Application 3/2021/0275

Location: Land behind The Dog Inn, Market Place, Longridge PR3 3RR

Proposal: Proposed erection of 9 new dwellings and associated works

I refer to the latest letter from United Utilities dated 10th November 2021 in which further additional information has been requested to be submitted in support of the application.

Planning Application
Site Sections / Street Scenes
Renderings
DATE 08/03/20

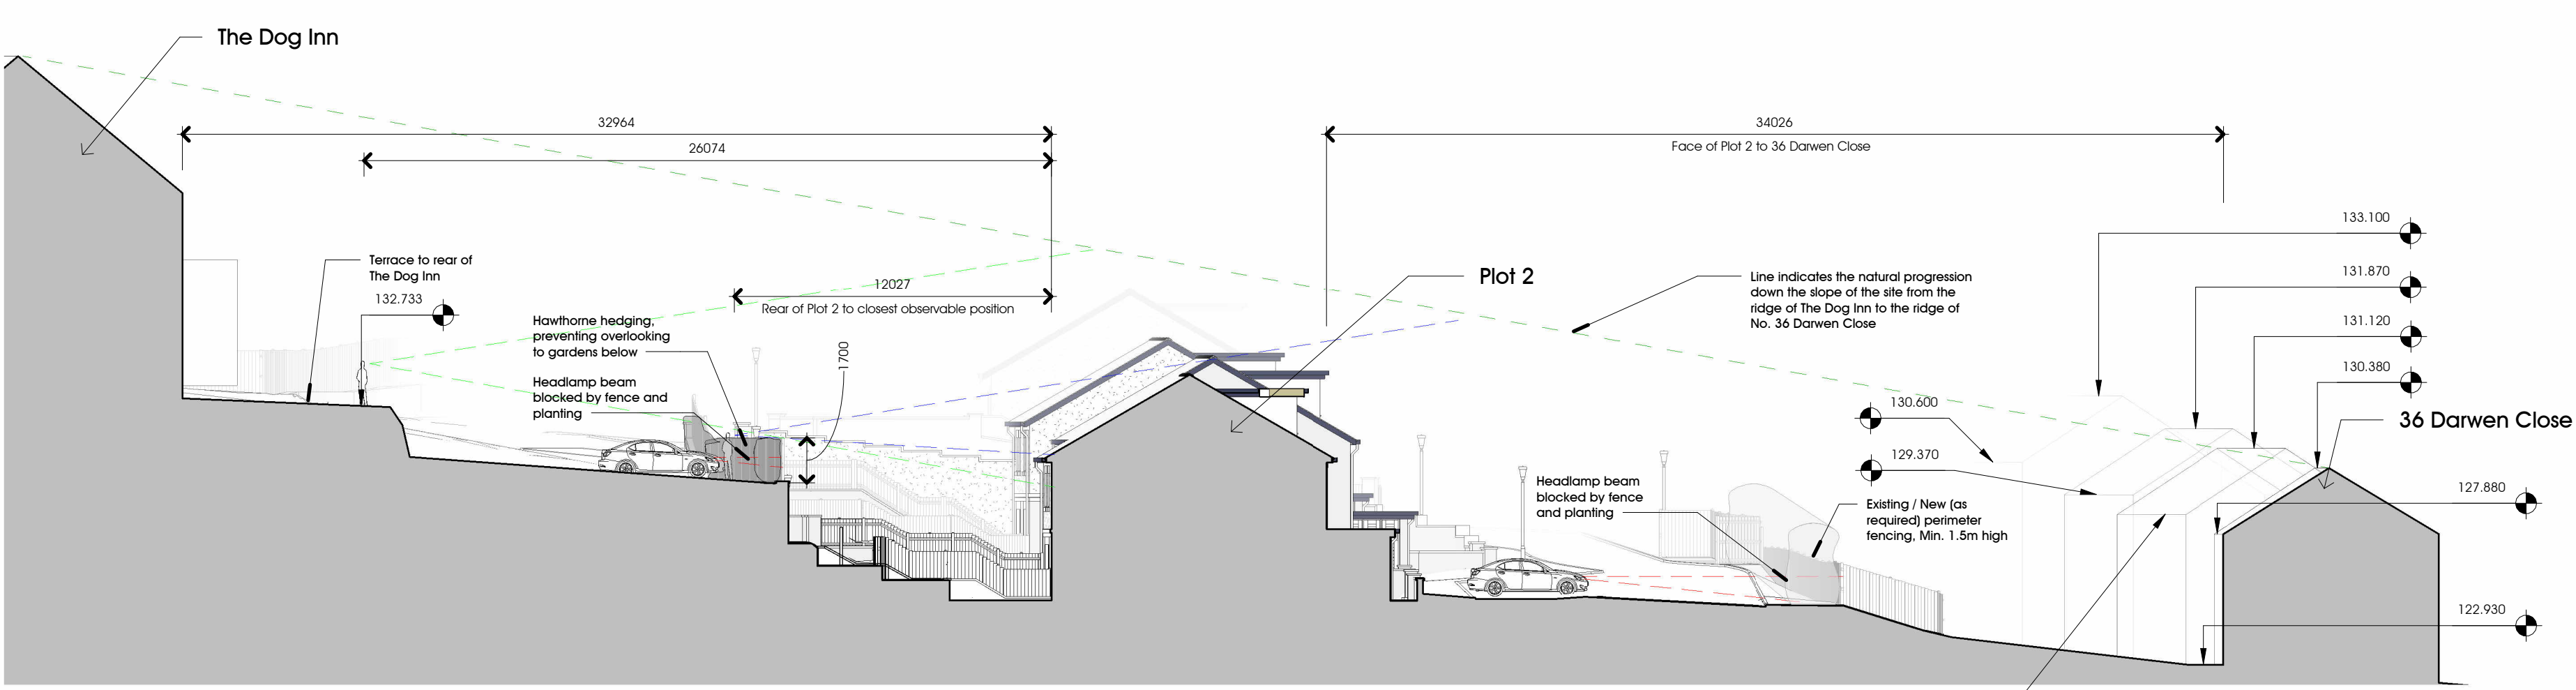
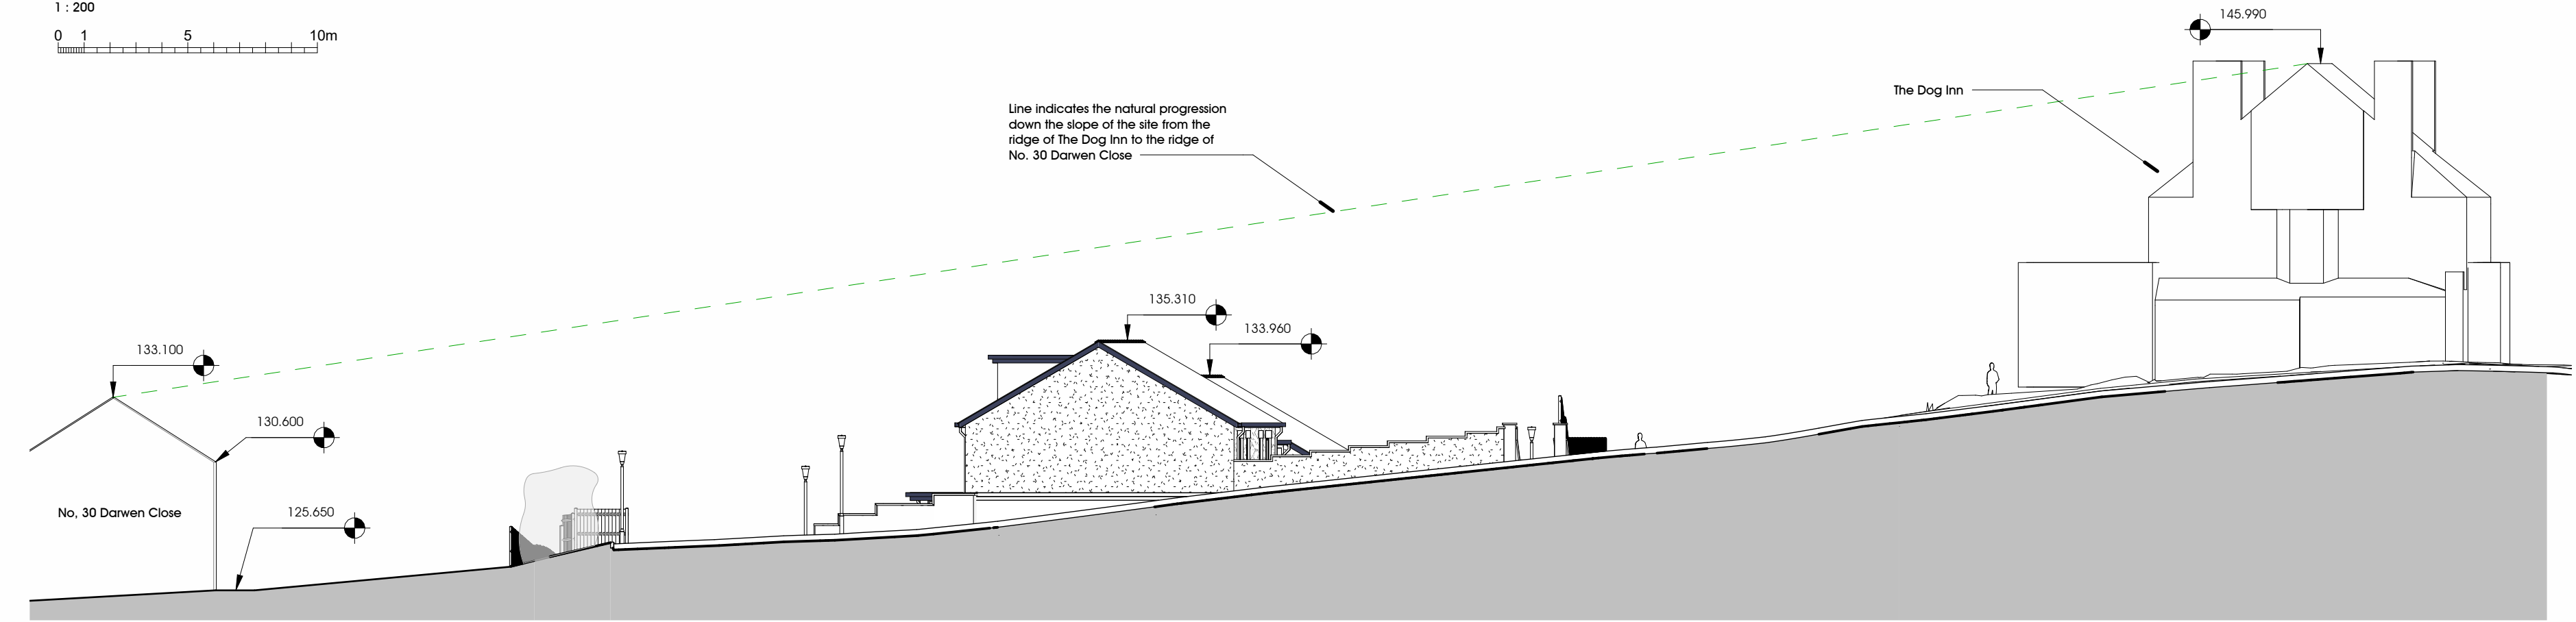
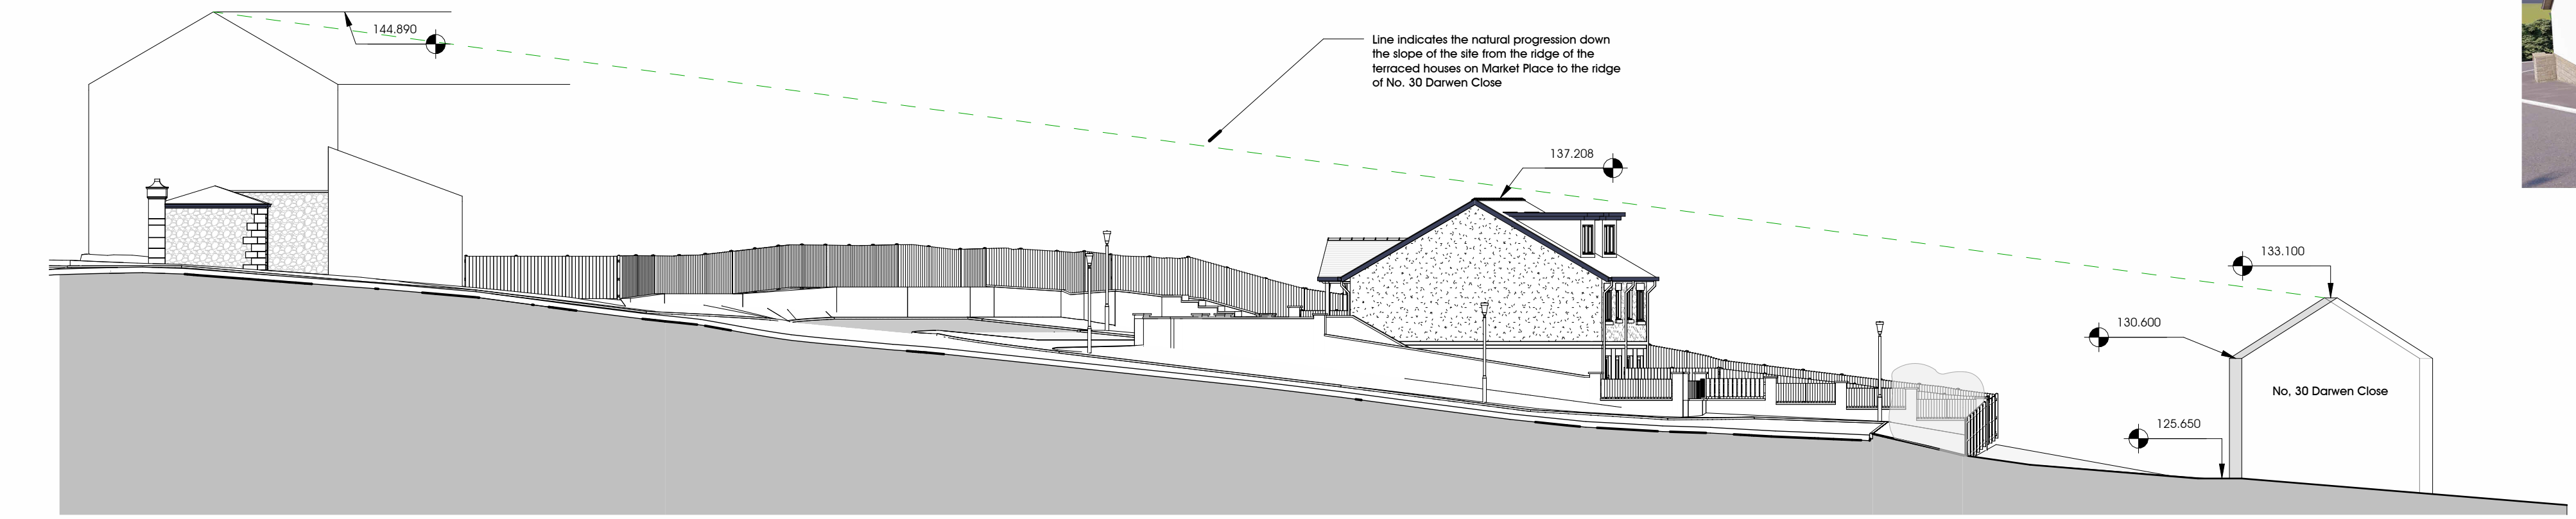
1. The finished floor levels for all proposed units and finished ground levels for the site. In addition further details for the surface water and foul water drainage arrangements are needed which is to include the proposed private drainage runs and connection points for each unit to the proposed drainage systems.

2. Details to demonstrate how any exceedance flows will be managed in practice for example through high kerbs and any raising of proposed ground levels. Details for any retaining wall structure and boundary treatment around the curtilage of the proposed properties with particular reference to plots 1 and 7.

Response: We attach to this letter the proposed site layout that shows plot finished floor levels and ground levels, along with a drawing showing sections through the site. Further details for the surface water and foul water drainage arrangements have been added to the

The drawings attached to this letter show the retaining walls and boundary treatment around the curtilage of the proposed properties.
